Re: USE OF PRE APP REPORT TO MILLFIELD HOUSE, MILLFIELD, BARNSTON, CM6 1LH.

Application No: UTT/23/0171/PA

PREAPP Description: Single Storey Rear Extension

Location: Millfield House, Millfield, Barnston, CM6 1LH.

PROPOSED NORTH-WEST ELEVATION
SCALE: 1:100 @ A1

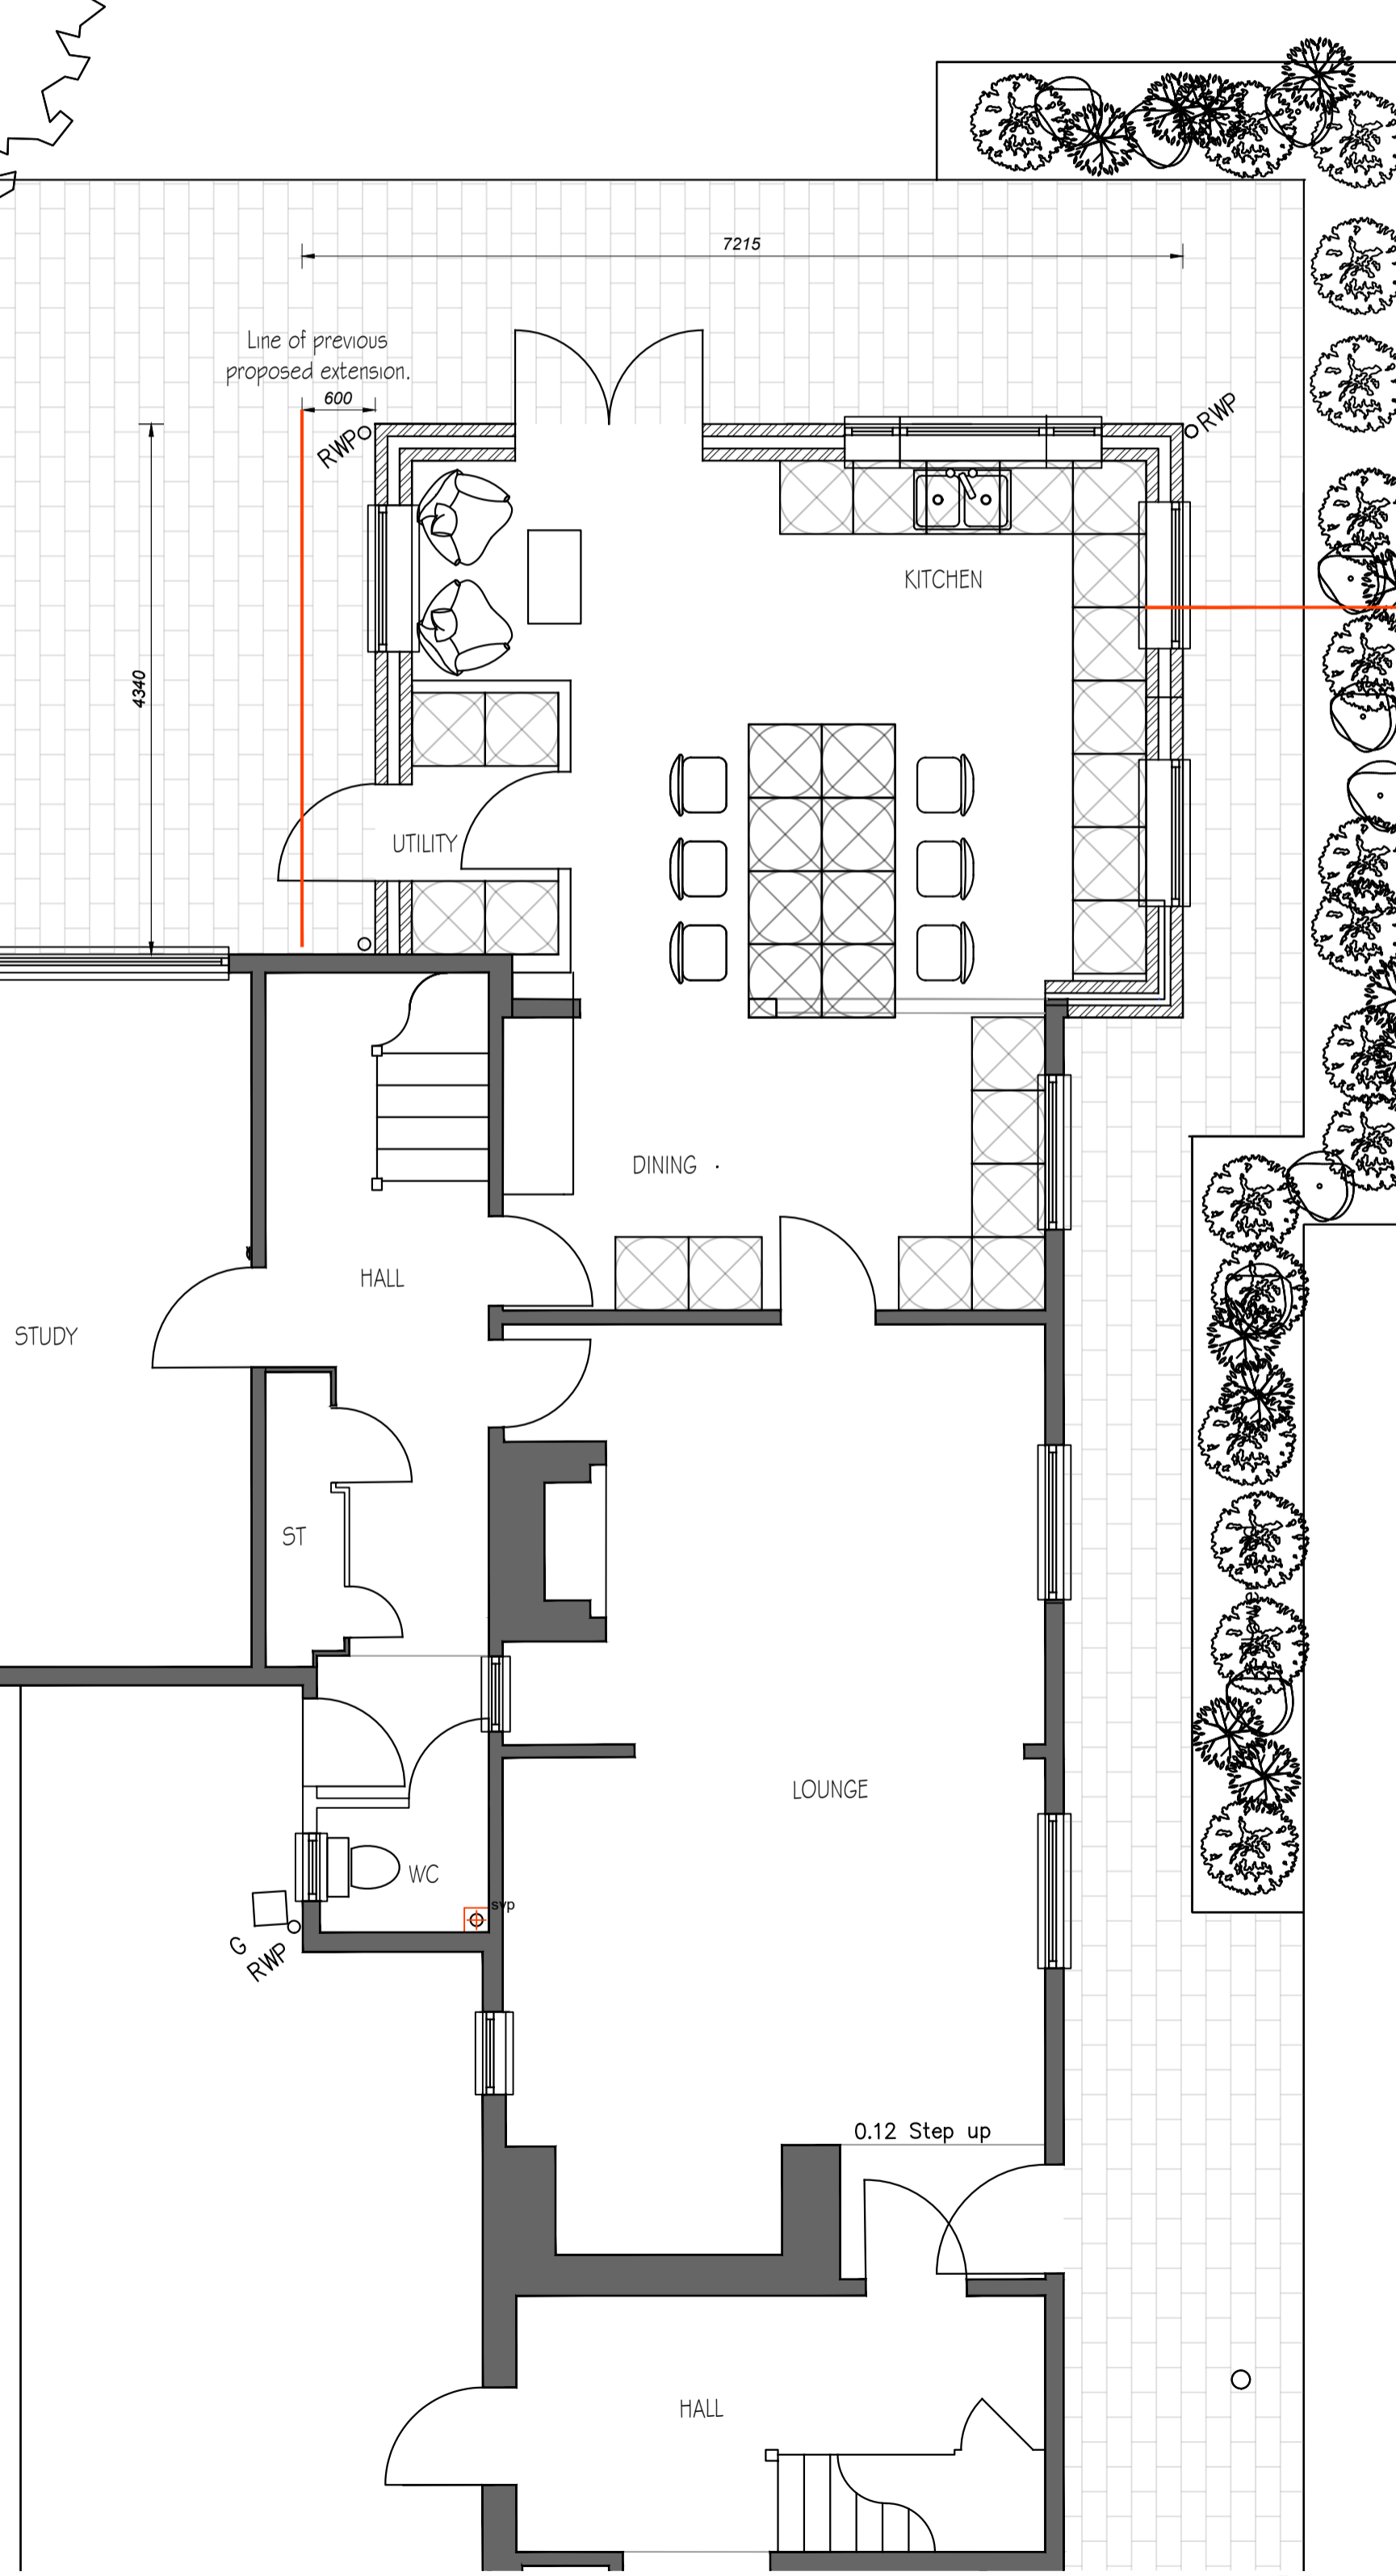
In line with previous advice, due to the extent to which the listed building has been previously extended and overwhelmed by modern additions, I would be able to support only a small increase in the footprint of the existing extension - in my opinion, the suggested 2.2 metres would be the absolute limit of additional development - and no increase in height. Retaining the subservience of this extension to the historic core of the building is key and it should continue to respect the gable end of the listed building and sit cleanly below the height of the first floor window cills on both the north and east elevations. In my view, due to the large quantum of existing modern additions on site which pay scant regard to the special historic and architectural interest of the host building, a design which favours a traditional roof form, fenestration and materials (timber windows and doors, natural slate roofing, a red brick plinth and rendered walls), would be far more sympathetic than another addition to a contemporary design. I would not, therefore, support a glazed gable or bifold doors in this sensitive context, and consider that traditional doors and windows should be able to provide sufficient glazing to deliver the desired views to the north.

- *I would not, therefore, support a glazed gable or bifold doors in this sensitive context, and consider that traditional doors and windows should be able to provide sufficient glazing to deliver the desired views to the north.* The original pre app meeting design, included a glazed gable and bi-fold doors, since the application report had been received, we have amended the design to suit comments. The glazed gable has now been removed, replacing it with a more sympathetic window, matching in existing elevations, also bi-fold doors have been removed and replaced with more sensitive double traditional French doors still allowing for the views to the north.

- *(timber windows and doors, natural slate roofing, a red brick plinth and rendered walls)* These three materials, suggested have been noted, and now have been placed on the design only. Meeting heritage / councils requests.

Connor Ferris Architects comments: *Overall, we would recommend the application should be approved, as we have made all the changes that were discussed on site at the Pre-app meeting, and mentioned in the above report. Glazed windows and bi-fold doors have been removed, the scale of the extension is smaller than the original refused application, and the materials specified are those recommended in this report.*
